Angmering Parish Council continue to **OBJECT** to the proposed Landscape and Site Lay- out Plans submitted with A/109/20/RES and the impact the development will have on the setting of the South Downs National Park.

For the following reasons we believe the application, which is based on the Parameter Plans approved by A/99/17/OUT, should be withdrawn.

INDICATIVE SECTION

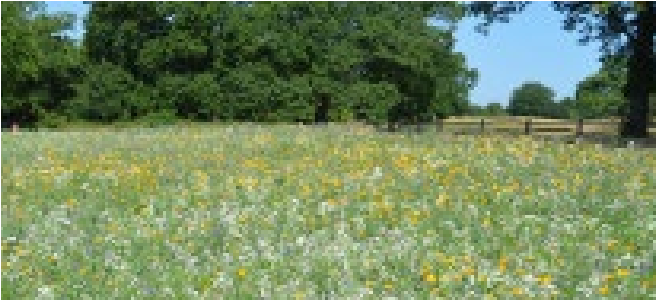
- a) There is a photograph of the actual hedgerow on the site's eastern boundary, which it estimates as being *"approximately 4m high"*. This is corroborated by Engineering Layout Sheet 1 A290-RM-401 Rev P3 as well as other detailed engineering plans, which all show the boundary fence height as 1.4m and the Hawthorn Hedge height as 3m.

- b) It is obvious the hedgerow is not capable of limiting views of the development from the national park, to just "glimpses of roofs over the existing vegetation".

- c) To deliver this objective there will need to be a significant increase in the width of the landscape buffer shown in the Parameter Plans to at least the 15m originally requested by Arun. More if it is to include parking lay-bys.

APC's Comments: Yet another comment based on what appears to be a "Google Earth desk top study". What does the width of a significant landscape buffer on the site's eastern boundary have to do with the distance of the boundary from the A280? The planting on the A280 cutting embankment is patchy and below site level.
